BUILDING 11 – EPPING PARK, STAGE 3

ACCESS REVIEW

Morris-Goding Accessibility Consulting

13th August 2012

DRAWING TITLE
ADAPTABLE UNITS - BLD 12

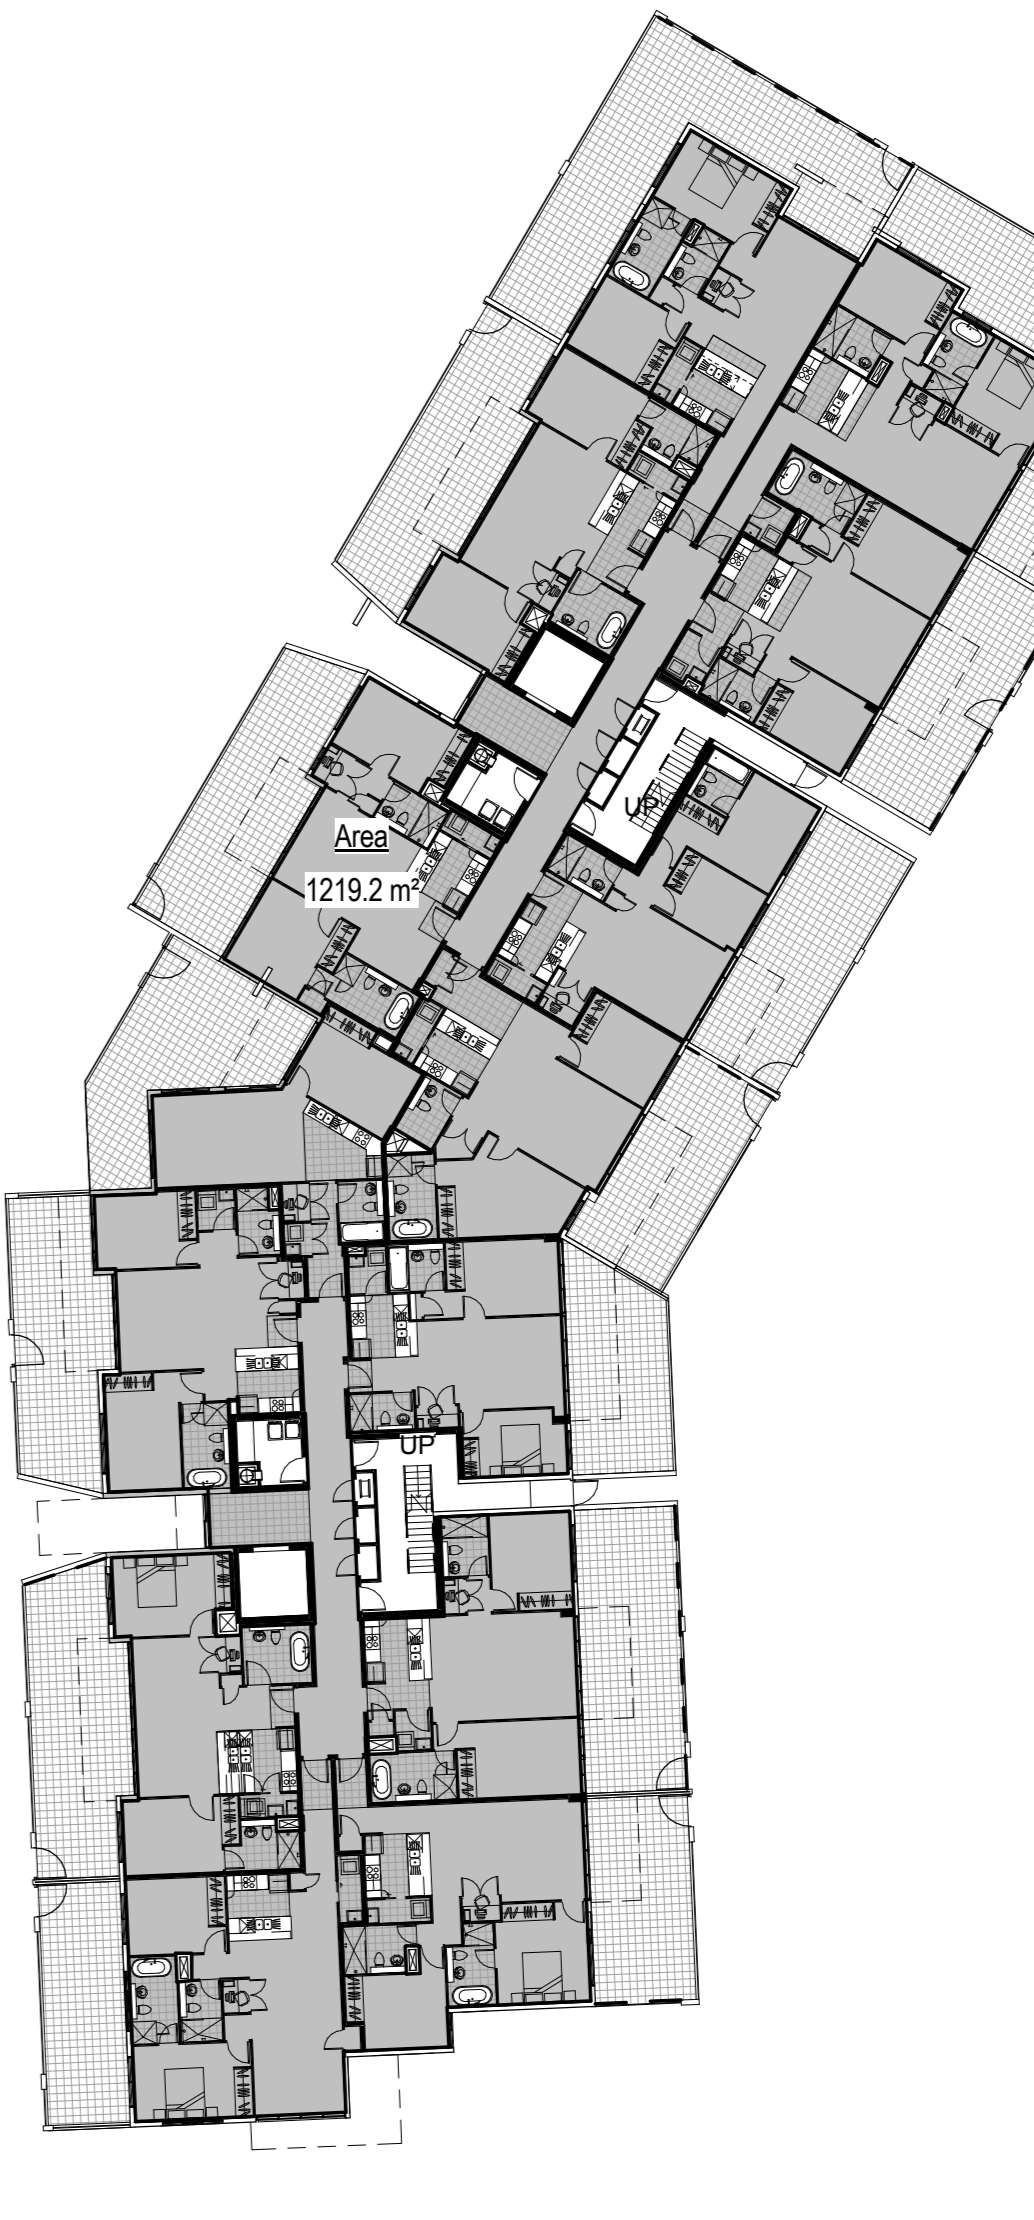
5.2. 2 Bed Adaptable Unit

The adaptable unit entry door has suitable clearances and circulation compliant with AS1428.1:2009 and AS4299. From the entry, there are suitable clearances to allow access to all areas of the unit compliant with AS1428.1:2009.

The kitchen is located adjacent to the entry door with an appropriate 1550mm diameter turning area between base benches achievable at post-adaptation compliant with AS4299. There is an appropriate 800mm wide workspace adjacent to the cooktop, sink and refrigerator.

UNITS - GO8, 108, 208, 308, 408 & 507

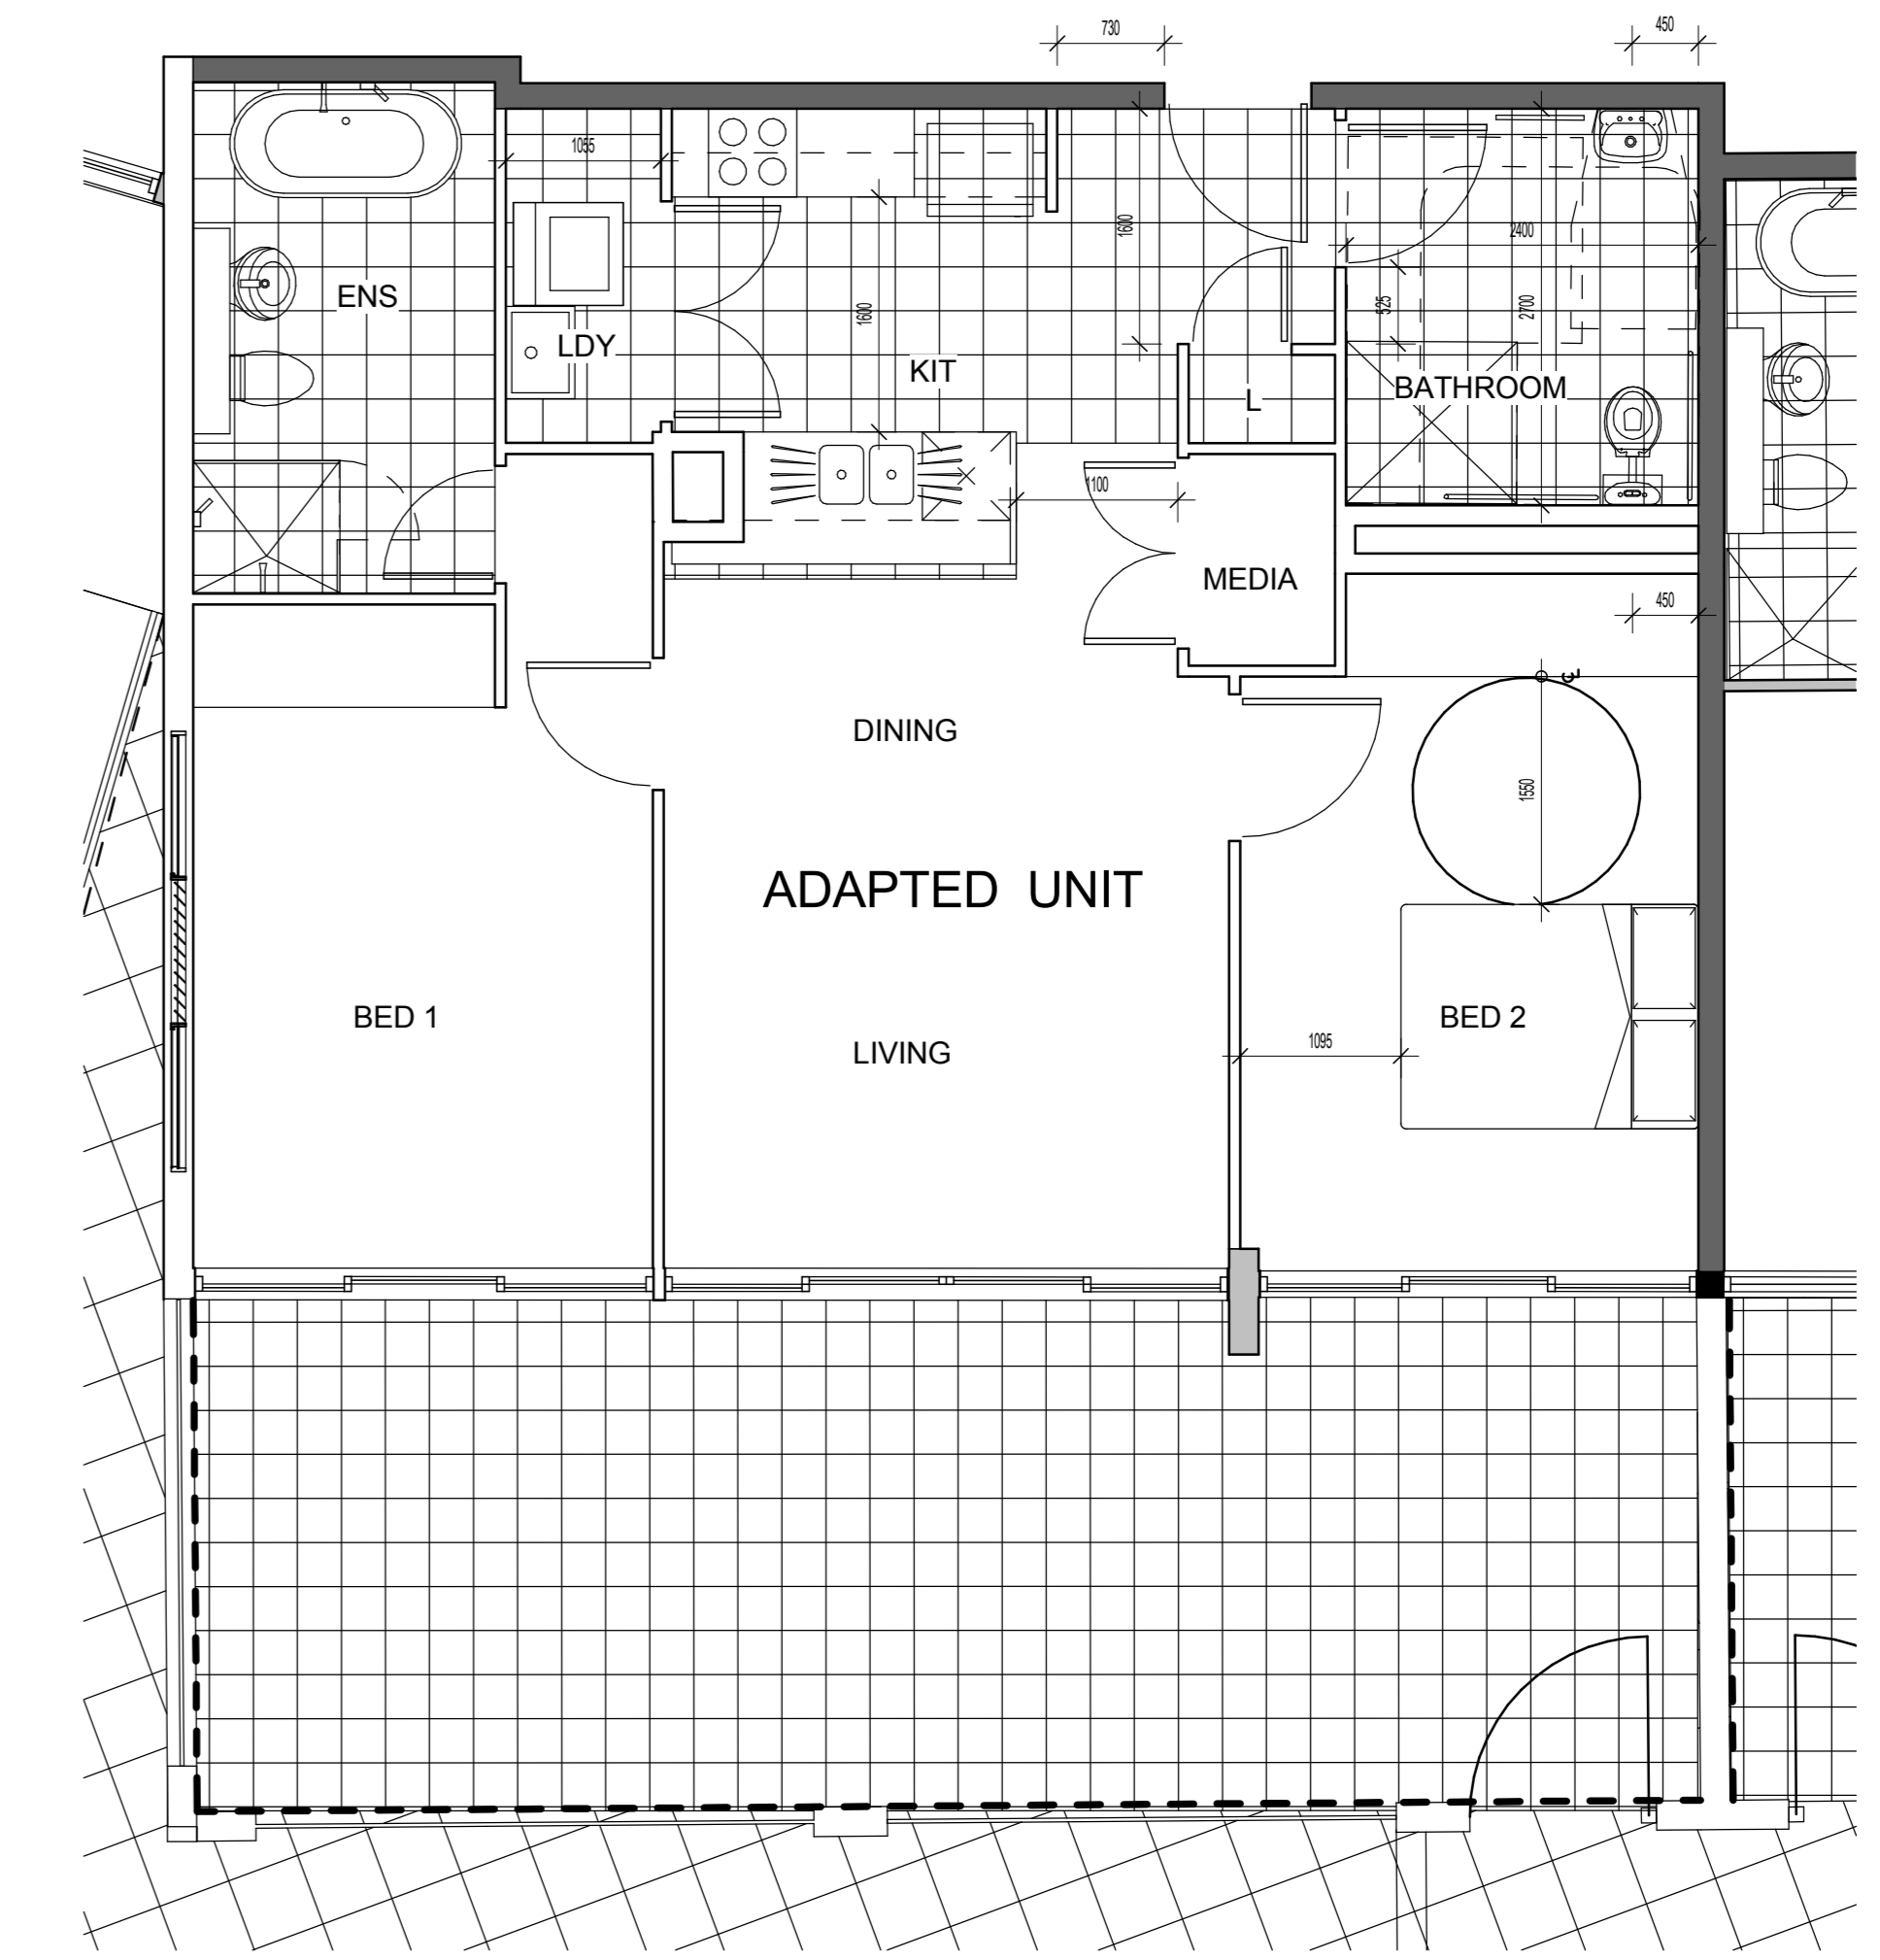
The kitchen is located adjacent to the entry door with an appropriate 1550mm diameter turning area between base benches achievable at post-adaptation compliant with AS4299. There is an appropriate 800mm wide workspace between the cooktop and refrigerator. The sink will need to be repositioned to allow for an 800mm workspace compliant with AS4299.

The main bedroom entry door has suitable clearances compliant with AS4299. There is an appropriate wheelchair turning area near the robe however modifications of the internal dimensions of the bedroom is required to ensure suitable wheelchair manoeuvrability.

- (i) Provide an appropriate 800mm workspace adjacent to the sink compliant with AS4299. Currently appears to be 700mm.
- (ii) Ensure the bedroom has suitable circulation areas of 1540mm adjacent to the robe with a 1000mm clearance adjacent to the bed. There needs to be a 1200mm circulation area at the base of the bed suitable for wheelchair manoeuvrability.
